Jeanie Bourke - Re: 714 Stevens Ave, UNE, BP#2015-01012 Plan Review Comments

From: Jeanie Bourke
To: Mark Chaloupecky
Date: 7/14/2015 9:27 AM
Subject: Re: 714 Stevens Ave, UNE, BP#2015-01012 Plan Review Comments
CC: 'Lita Semrau'

With regards to the 2009 UPC fixture count for the required plumbing fixtures:

**SANITARY PIPING
PLAN ~ LOWER LEVEL**

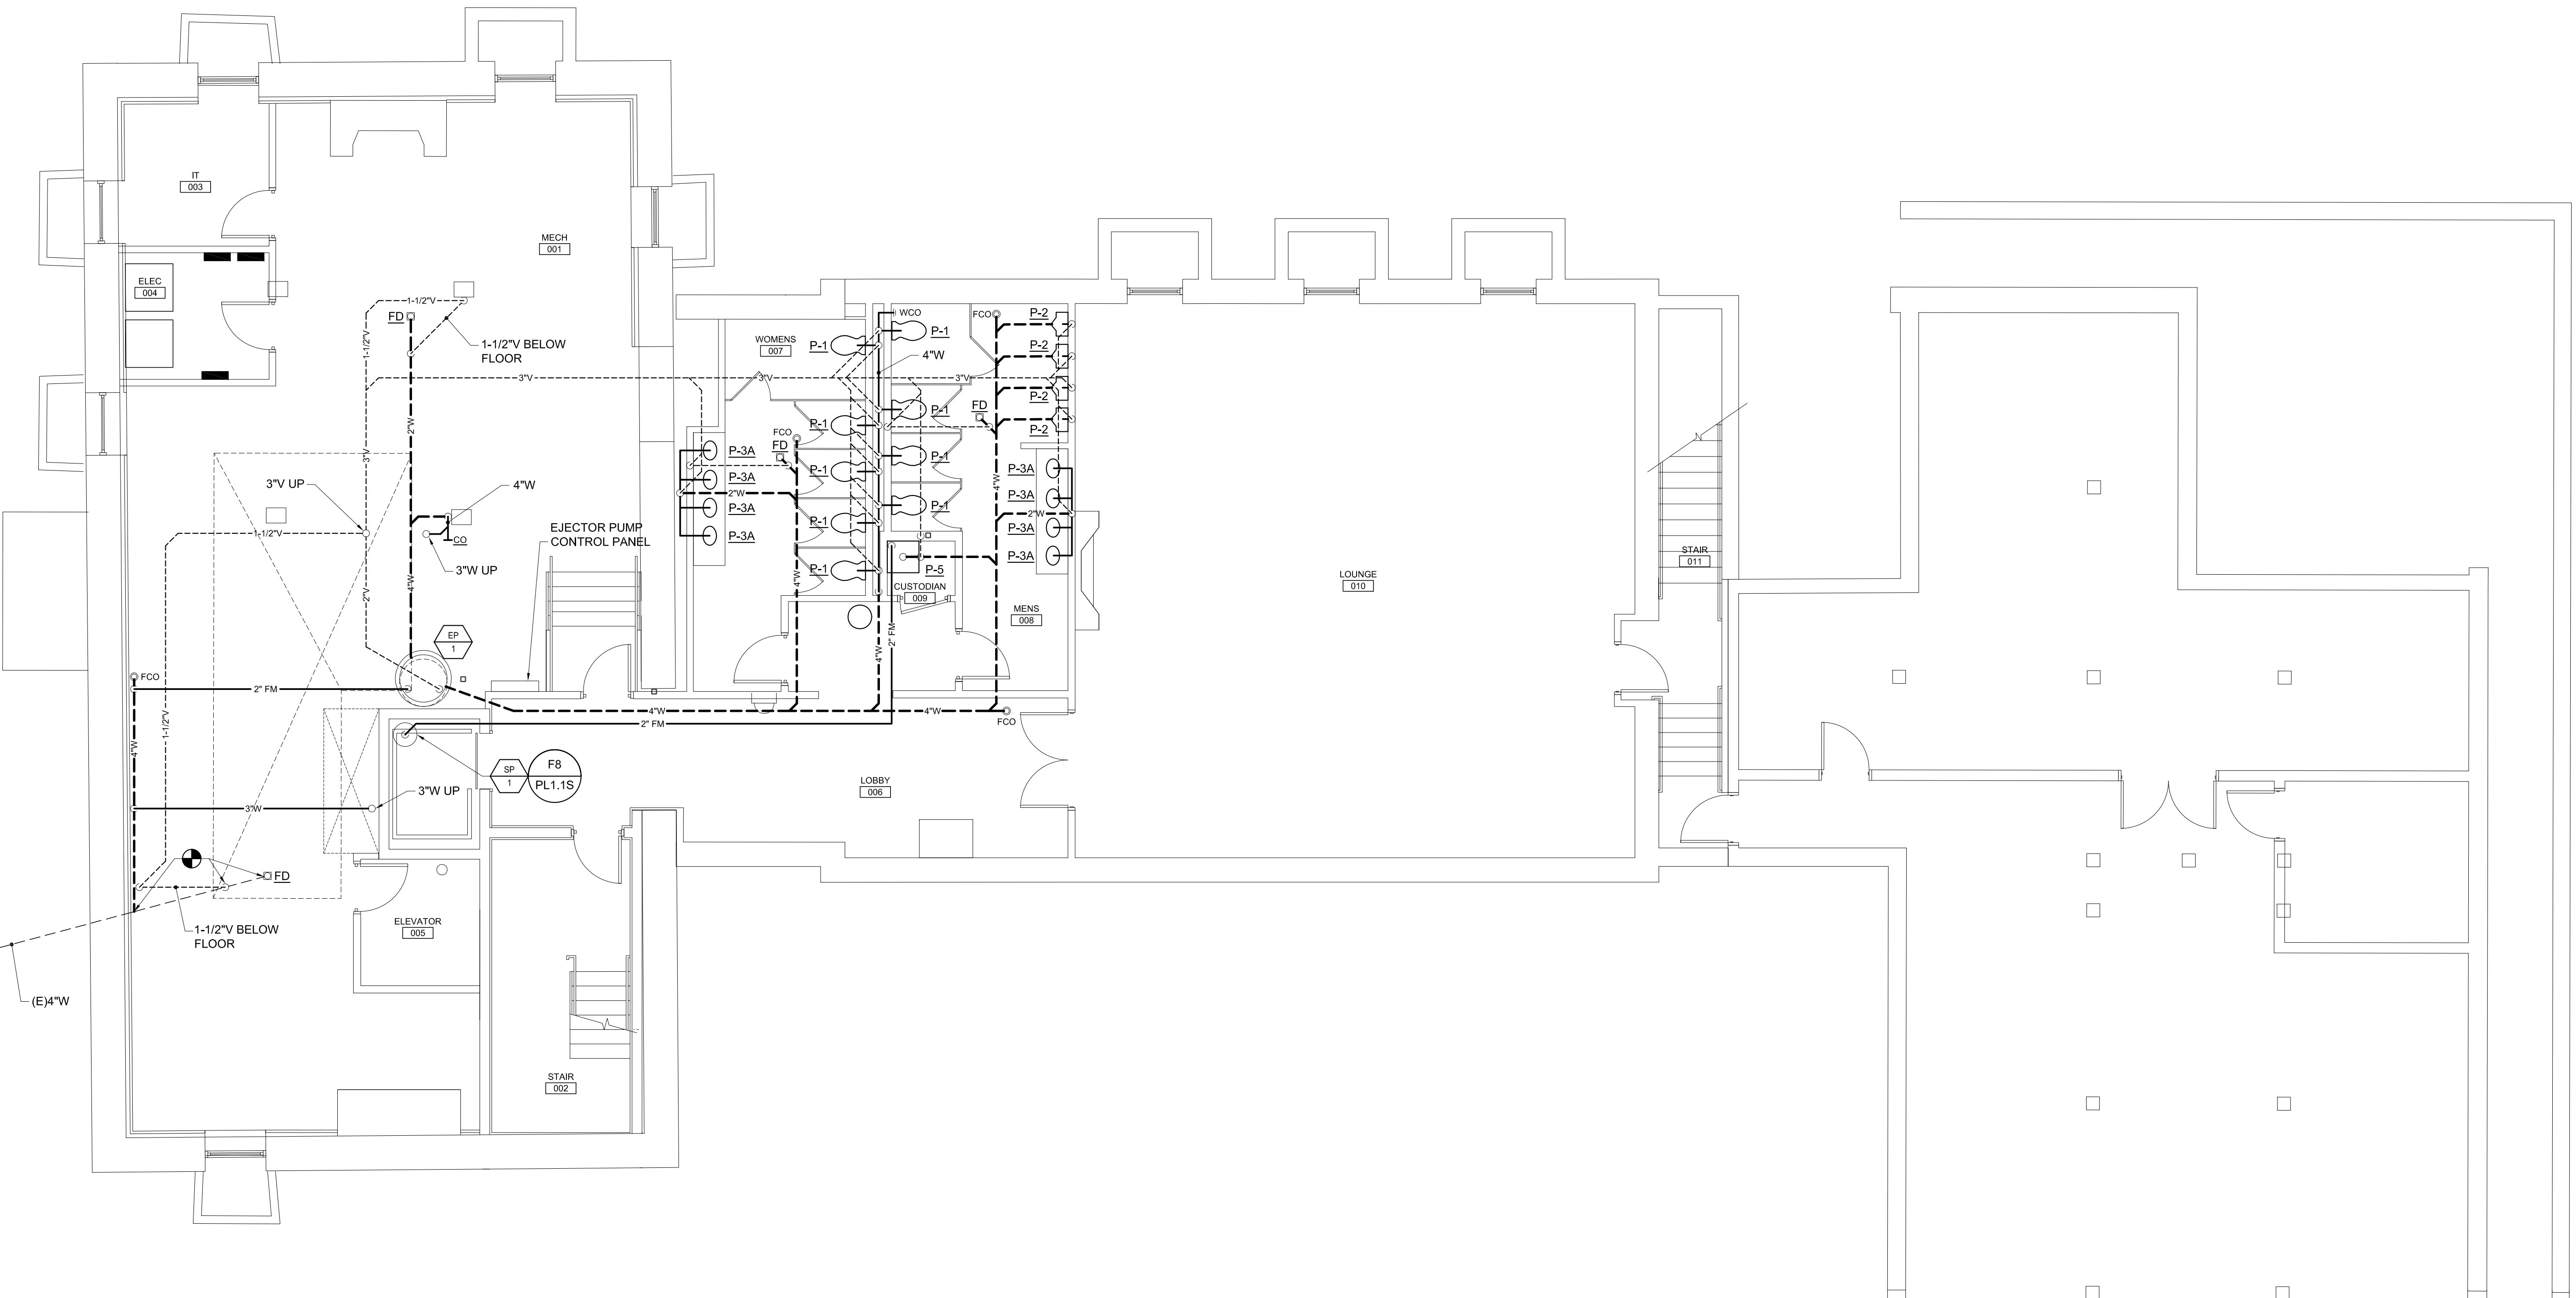
We have a large Men's restroom and a large Women's restroom located on the Lower Level. But we also have three (3) unisex restrooms located on the Second Level. Usually, restroom fixtures allow for between 30 and 40 occupants each, depending on the fixture. However, per UPC section 413.3(2) a unisex restroom can only be used in a situation with 10 occupants or less (not 30-40). Therefore, if we have three (3) unisex restrooms, the maximum amount of occupants they can satisfy is 30.

We are left with 305 occupants (152.5 men and 152.5 women).

Men

Toilets: 1/40 occupants = 4 toilets

Urinals: 1/35 occupants = 5 urinals

Lavatories: 1/40 occupants = 4 lavatories

Women:

Toilets: $1/30$ occupants = 5.08 toilets (we are officially asking for relief from the .08 part.....or .1 if we round up.)

Lavatories: $1/40$ occupants = 4 lavatories

Therefore, if we are graciously granted relief from the .08 Women's toilet, we are short one urinal in the Men's room on the Lower Level and we will add it to the restroom.

Thank you for the detailed UPC review. Please take this as confirmation to proceed with the design as requested.
